Kevin Cox
Crime Prevention Design Advisor
Thames Valley Police Headquarters South
Oxford Road
Kidlington
Oxfordshire
OX5 2NX

REF: 21/02180/REM

**Location: OS Parcel 9507 South Of 26 And Adjoining
Fewcott Road Fritwell**

03 August 2021

Plots 01, 17 & 28
Floor Plans and Elevations

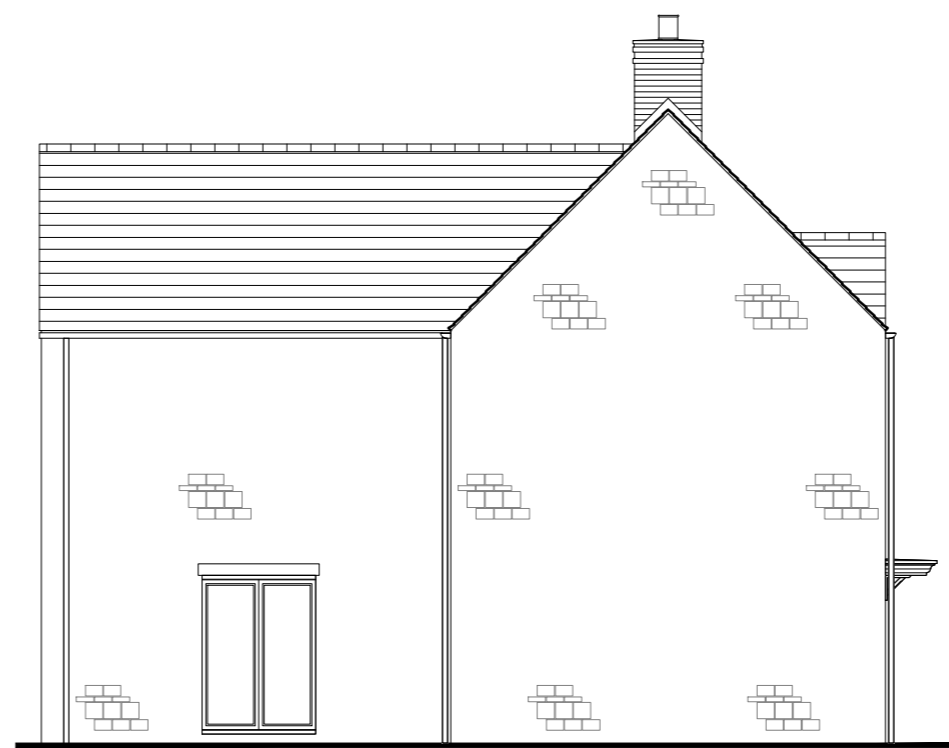
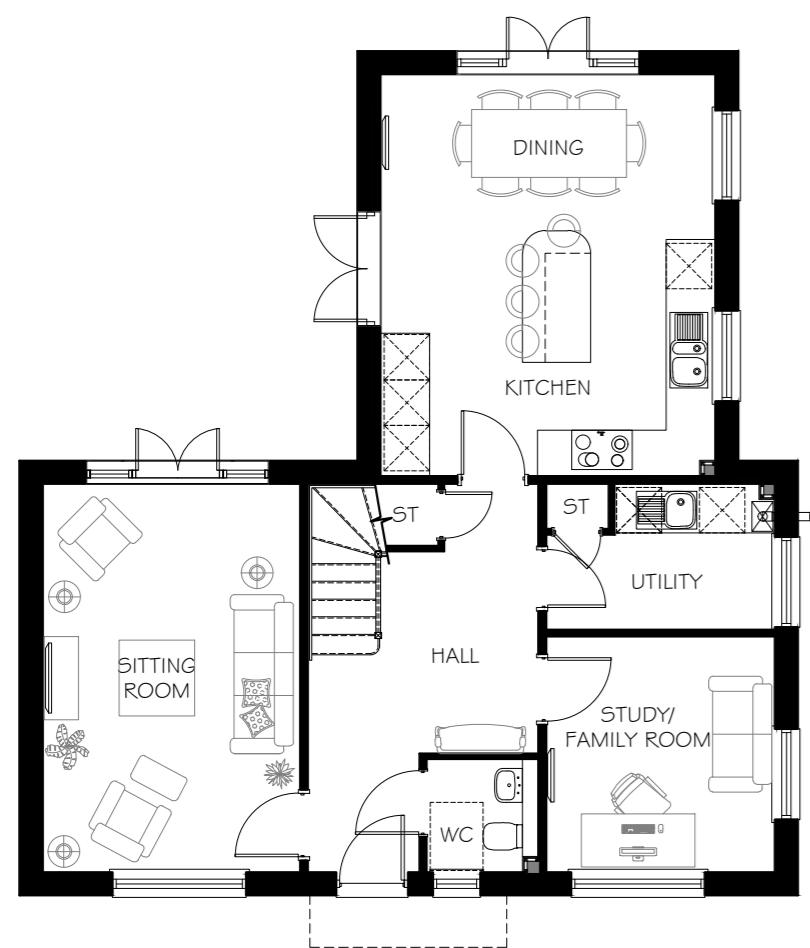
I ask that defensible space with planting to a depth of at least 1m must be provided to all private boundaries abutting the public realm, and I recommend thorny species such as *Pyracantha coccinea*, which provides a very difficult to scale but attractive boundary. This is not currently the case for plots 15, 17, 18, 23 for example. Where tree planting is provided alongside dwelling boundaries, it is important that the trees and any associated support systems are designed and located so that they do not provide a climbing aid over the private boundary.

Plots 05 & 06  
Floor Plans and Elevations

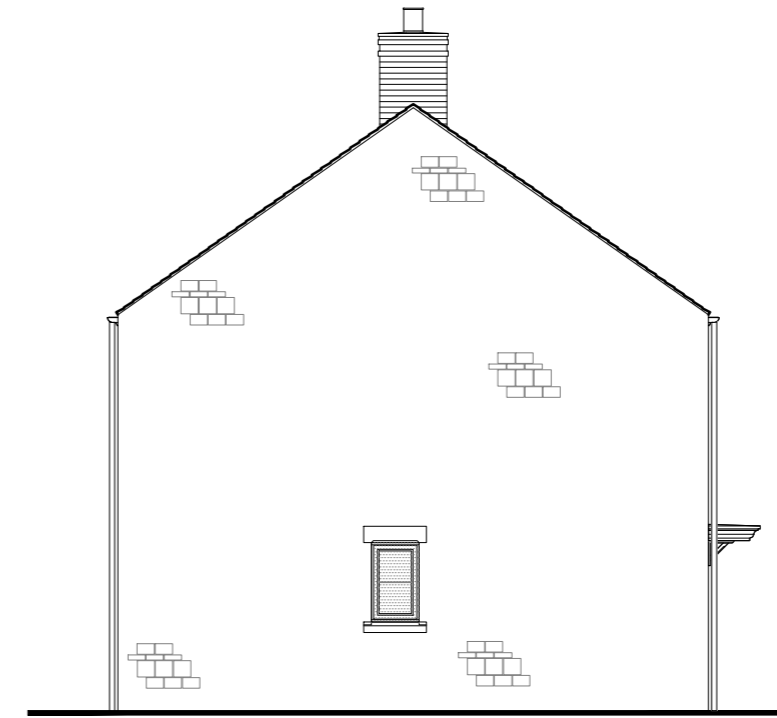
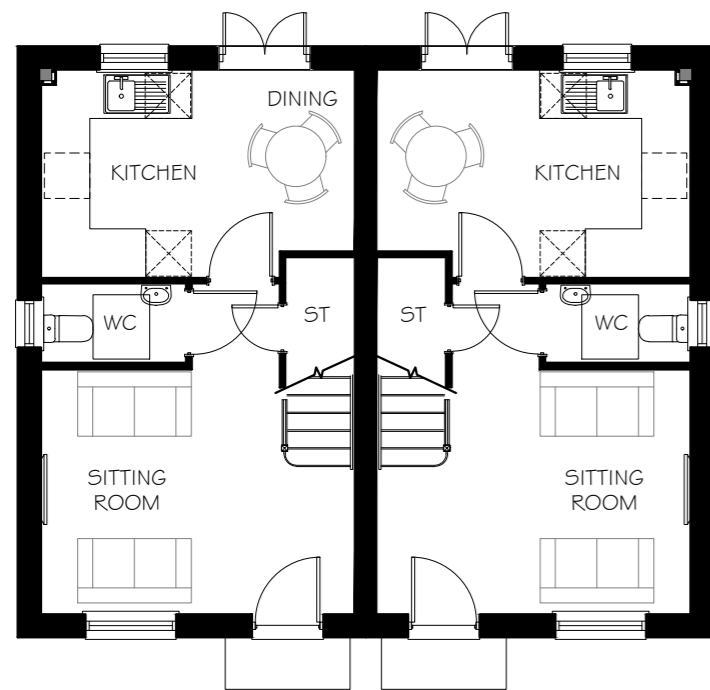
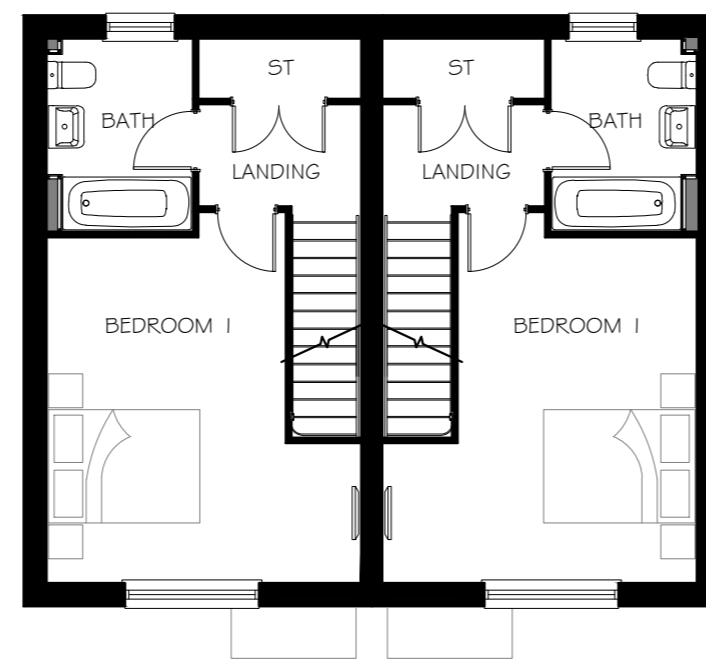
I ask that the rear access route for plot 6 is secured with a robust self-closing gate, which is secured key operated lock operable from both sides. This gate should be in line with the secure fence line.
